Side and rear extension

32 Tennyson Avenue Rustington

Thank you for your internet representation made on 7th May 2013 which has been recorded as '**an objection**' with the comments as follows:

Drawing No. TAR/002 Rev. B
Scale 1:100 & 1:50 @ A2
Date July 2012 Drawn DPS

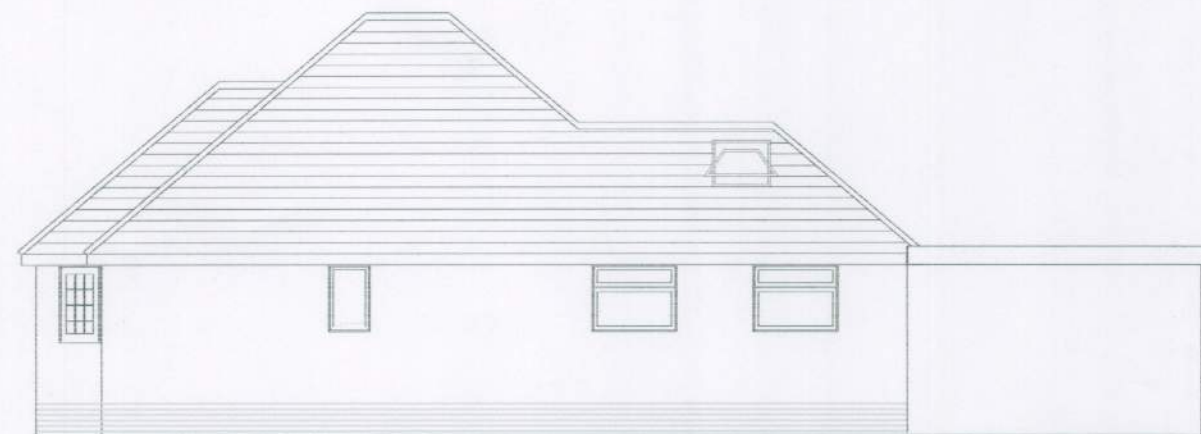
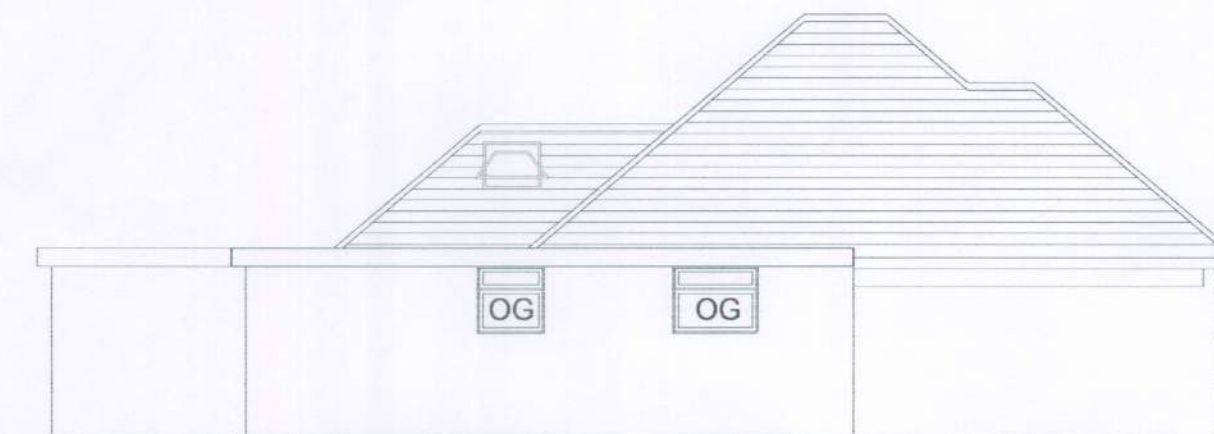
As an addition to my previous objection, if the garage roof is raised to the level of the rest of the proposed extension, then this would be out of proportion and out of keeping with the rest of the neighbourhood, and would set a precedent for similar sized building works in the area.
